Your Ref: 2020/91468
Our Ref: W007244

23rd July 2020

Former North Bierley Waste Water Treatment Works Oakenshaw - Discharge of conditions 5 (Phasing Plan), 11 (Sewer Overflow), 13 (Foul Water Drainage), 14 (Discharge of Surface Water), 23 (Flood Risk) and 24 (Disposal of Surface Water) on previous permission 2016/92298 for outline application for re-development of former waste water treatment works following demolition of existing structures to provide employment uses (use classes B1(c), B2 and B8)

S38 GENERAL ARRANGEMENT

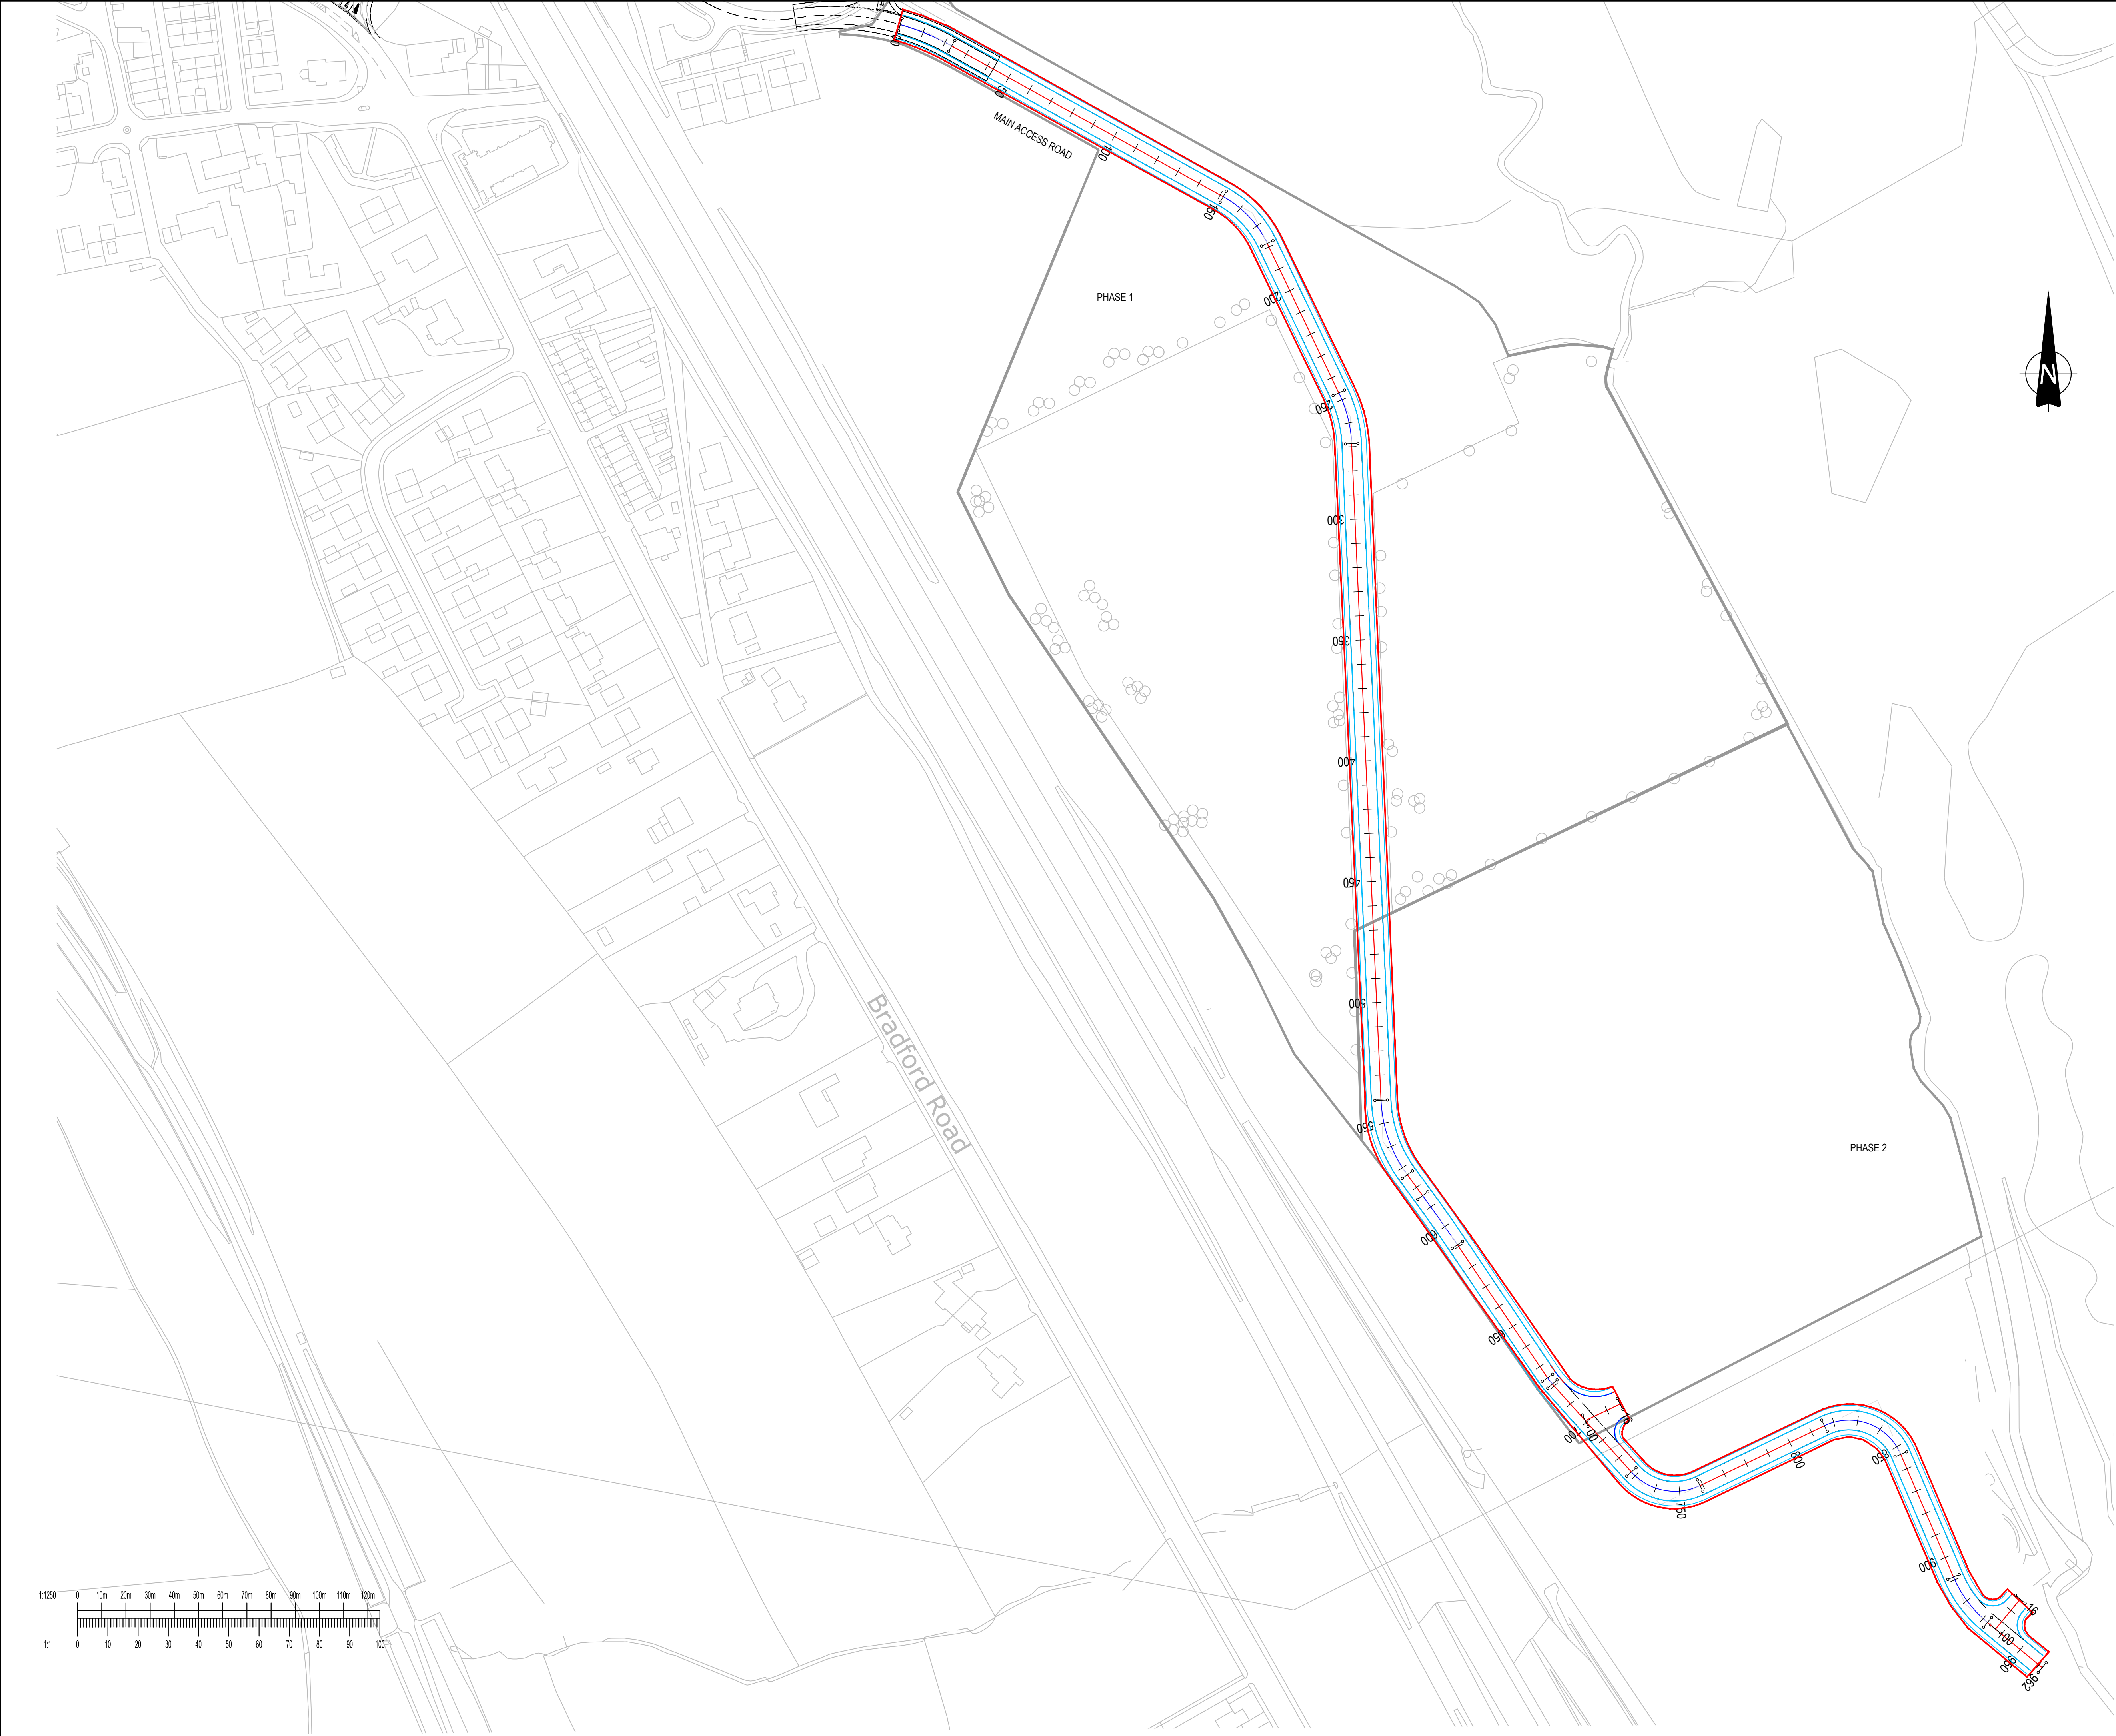
1) From the submitted information, none of the drawings indicate enough information for us to agree to the development proposals.

We require a detailed masterplan which includes the surveyed positions of the sewer apparatus (including the CSO) crossing the site. The masterplan must also indicate the required access routes to the CSO, with all the relevant sewer stand-off distances adhered to.

TITLE: SITE PHASING PLAN

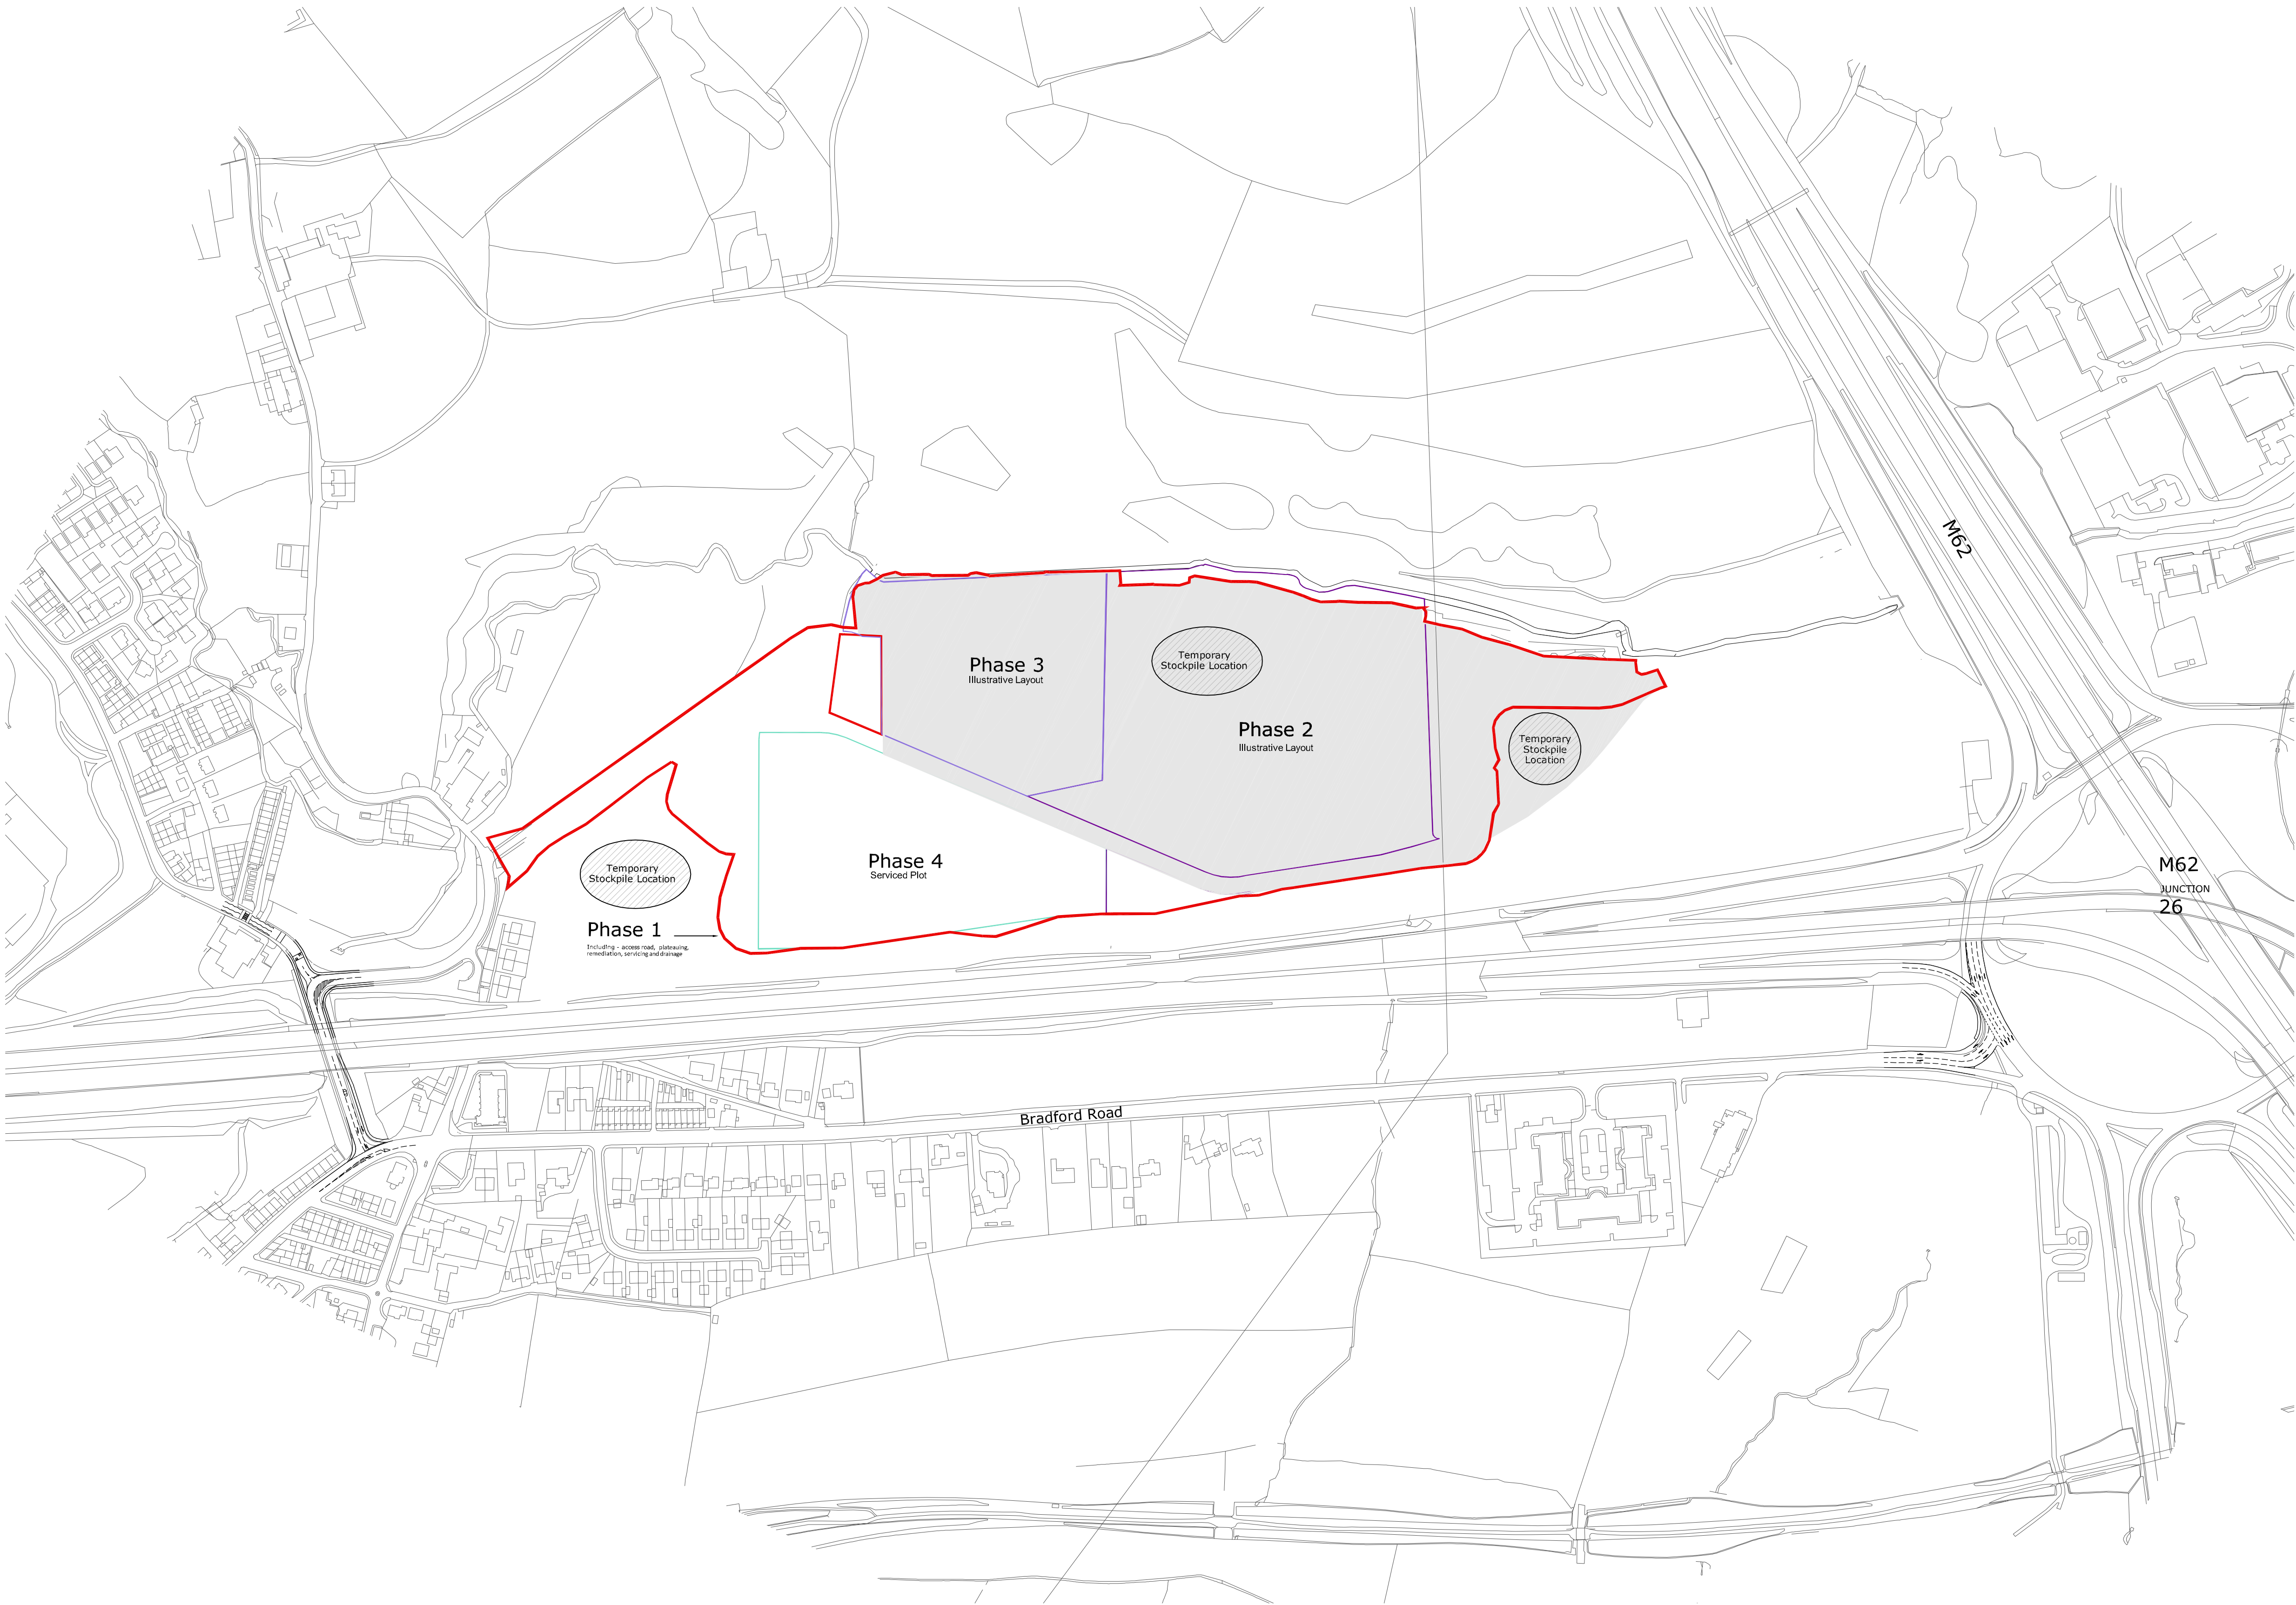
Yorkshire Water objects to the discharge of conditions 5, 11 and 13.

We also require the relevant phasing information regarding the construction and discharge of foul water to the public sewer network.
